**RE: Encompass Health
7000 Jefferson NE
Grading Plan Stamp Date: 10/17/19
Hydrology File: D17D061A**

RE: **Encompass Health**
7000 Jefferson NE
Grading Plan Stamp Date: 10/17/19
Hydrology File: D17D061A

Based on the submittal received on 11/7/19, this project cannot be approved until the following corrections are made:

Reference: Encompass Health
7000 Jefferson NE
Grading Plan Stamp Date: 5/23/19
Hydrology File: D17D061A

PROJECT NO: 019-00712-00

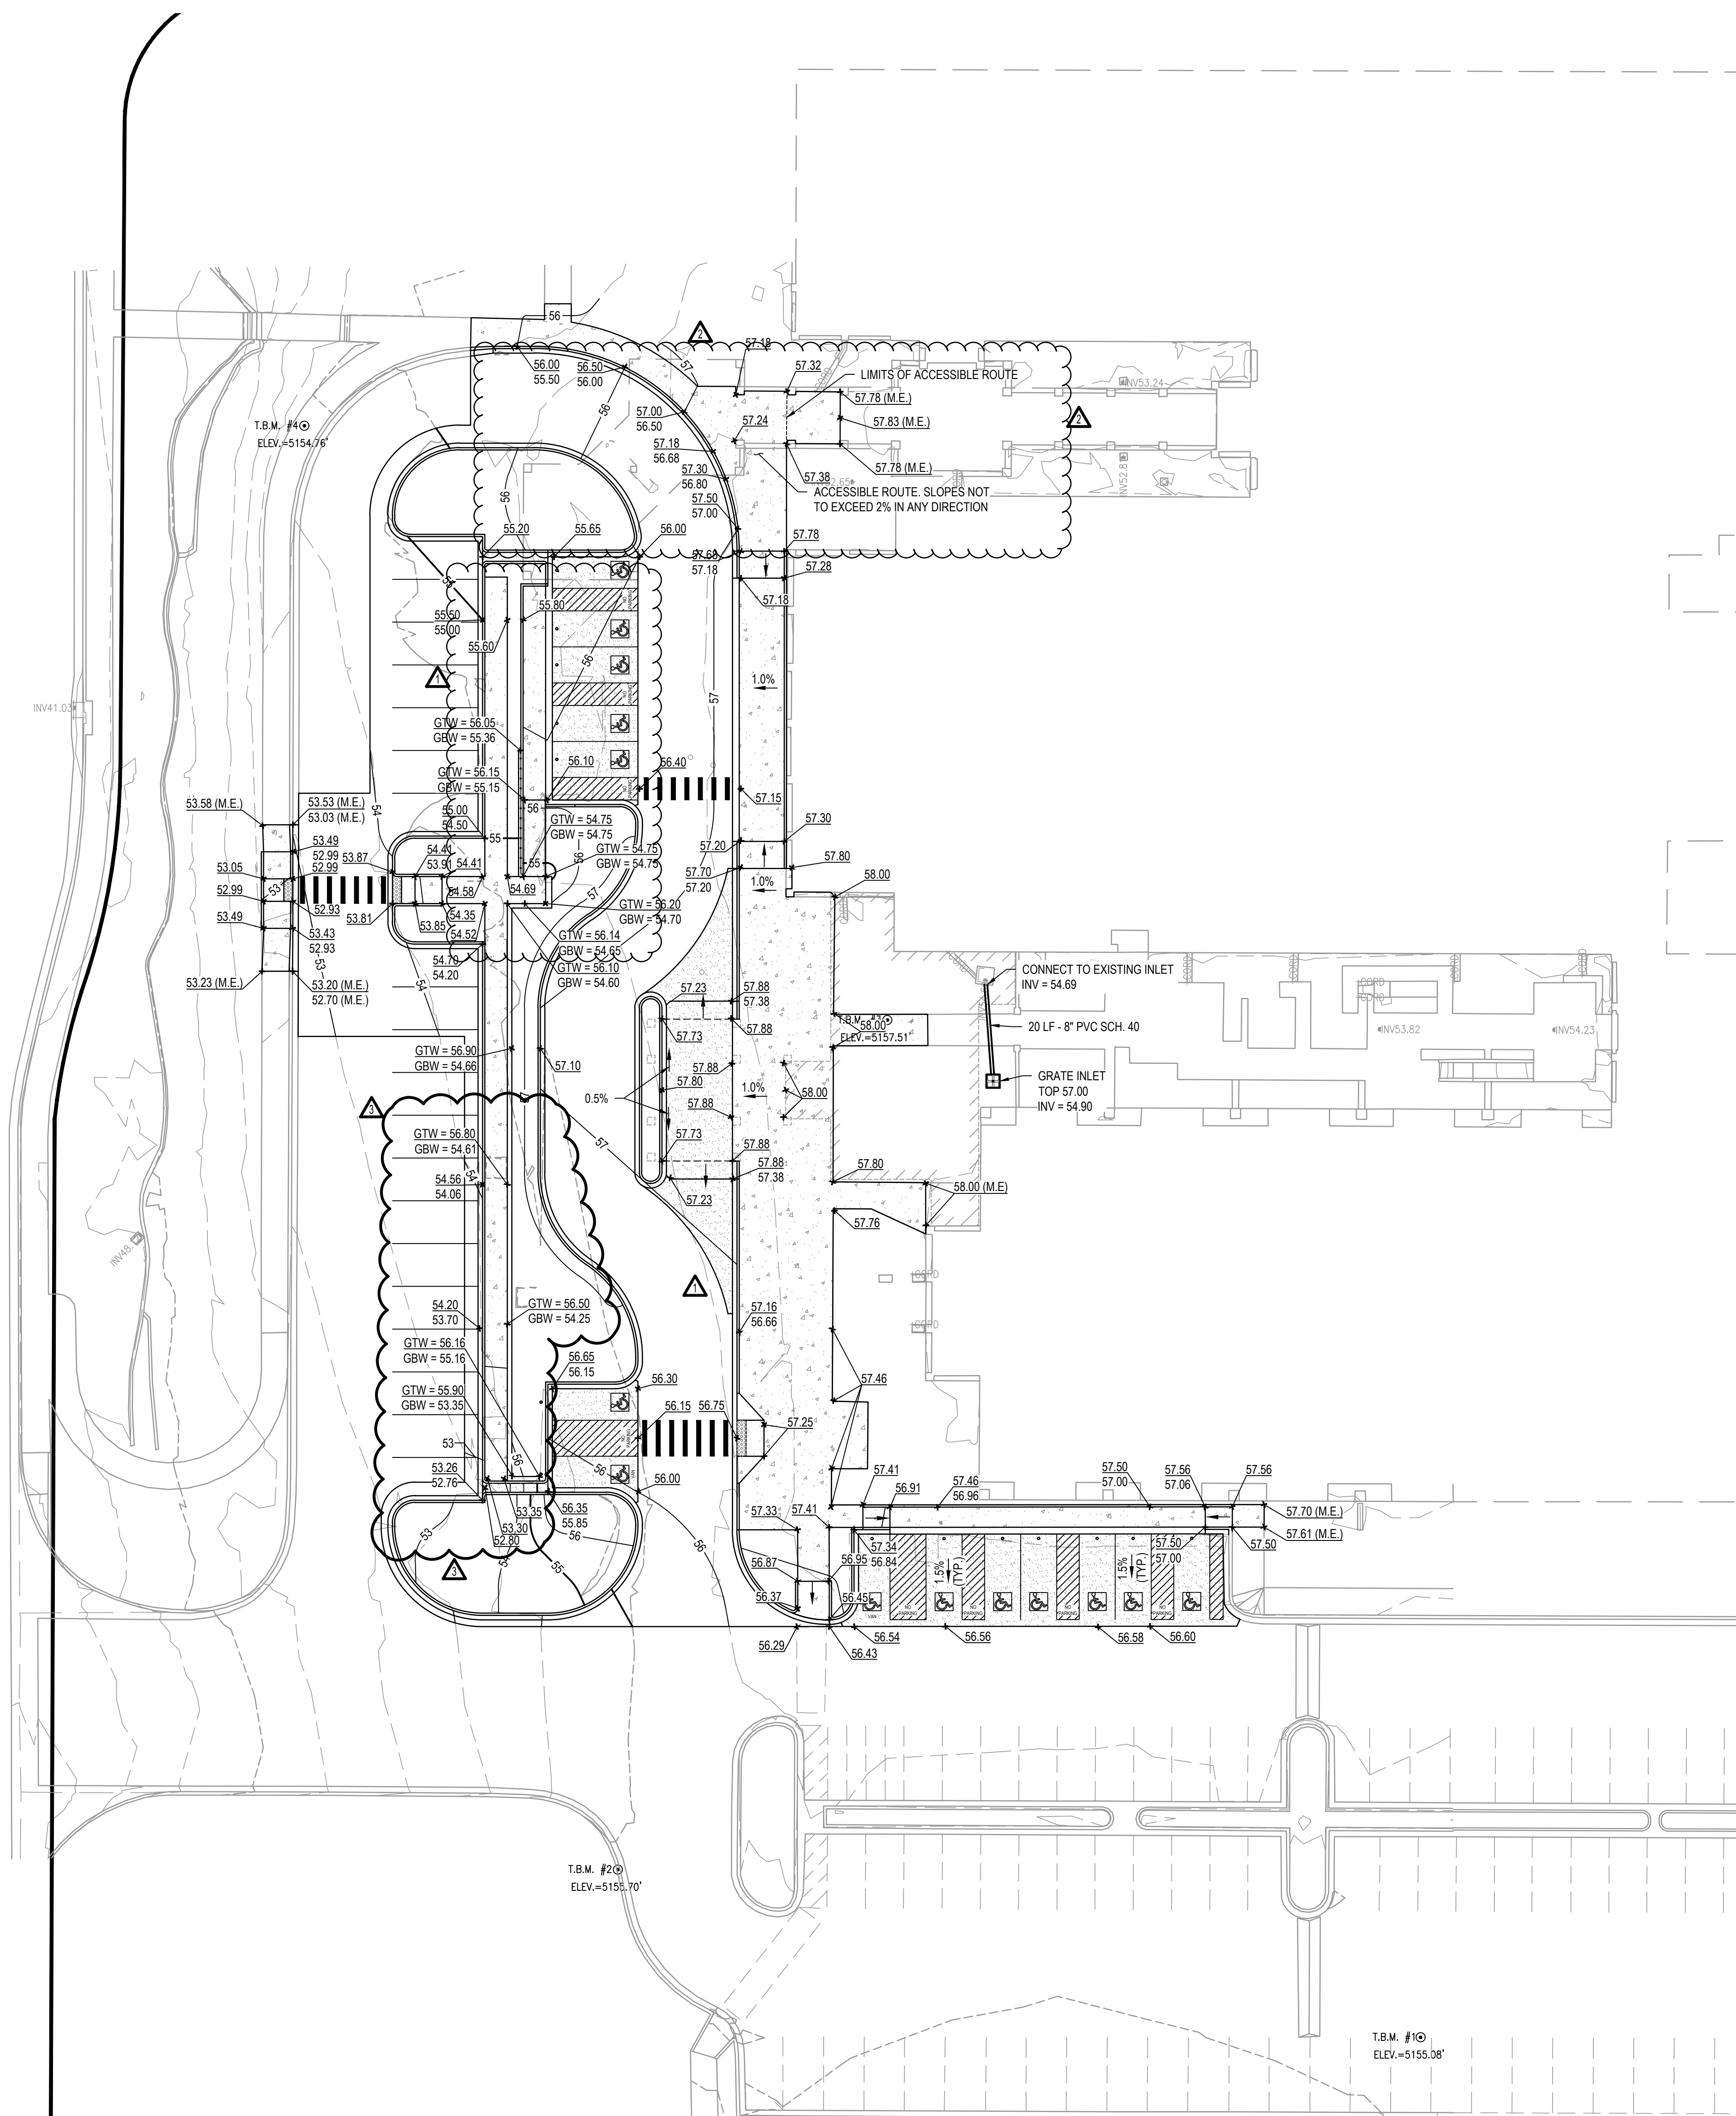
1. Payment in Lieu (Amount = $534CF \times \$8/CF = \4272 , per sheet C3.0) of onsite management of the SWQV must be made.
2. Provide a resubmittal (mailed to: City of Albuquerque Planning Department, Attn: Hydrology Section- DRS, 600 2nd St NW, Albuquerque, NM 87102) including: a new DTIS form, the treasury deposit slip, and check for the Payment in Lieu amount. There is no resubmittal fee for his activity; please include a copy of this letter when resubmitting in order to receive the reduced fee.

Response: Noted.
7. Provide management onsite for the Stormwater Quality Volume (SWQV) in accordance with the new drainage ordinance, § 14-5-2-6 (H) enacted 10/2/18 (Council Bill C/S O-18-2). To calculate the required volume to be captured, multiply the redeveloped impervious area (SF) by 0.26 inches for the 80th percentile storm.

8. Runoff from the redeveloped impervious areas needs to be routed into the stormwater quality (SWQ) ponds. Please provide the SWQ volume calculations for each basin draining to each pond.

9. You may also elect to make Payment-in-Lieu of onsite management for the bypass volume. In order to pursue this, the plan must state that: you could provide onsite management, you do not want to (due to cost or convenience), and you are electing to make the Payment in lieu of onsite management. The bypass volume must be quantified; a treasury deposit slip can then be generated for the bypass amount at a rate of \$8/CF.

Response: Stormwater volume to be treated determined by multiplying the redeveloped impervious area (24,634 SF as shown in the exhibit on the plans). The total volume to be treated is calculated as 534 CF.

Response: N/A. Payment-in-Lieu of treatment option is being pursued. The required treatment volume is 534 CF as shown in the Water Quality Calculations on Sheet C3.0.

Response: Payment-in-Lieu option will be pursued. The total amount is determined to be \$4,272 ($\8×534 CF)
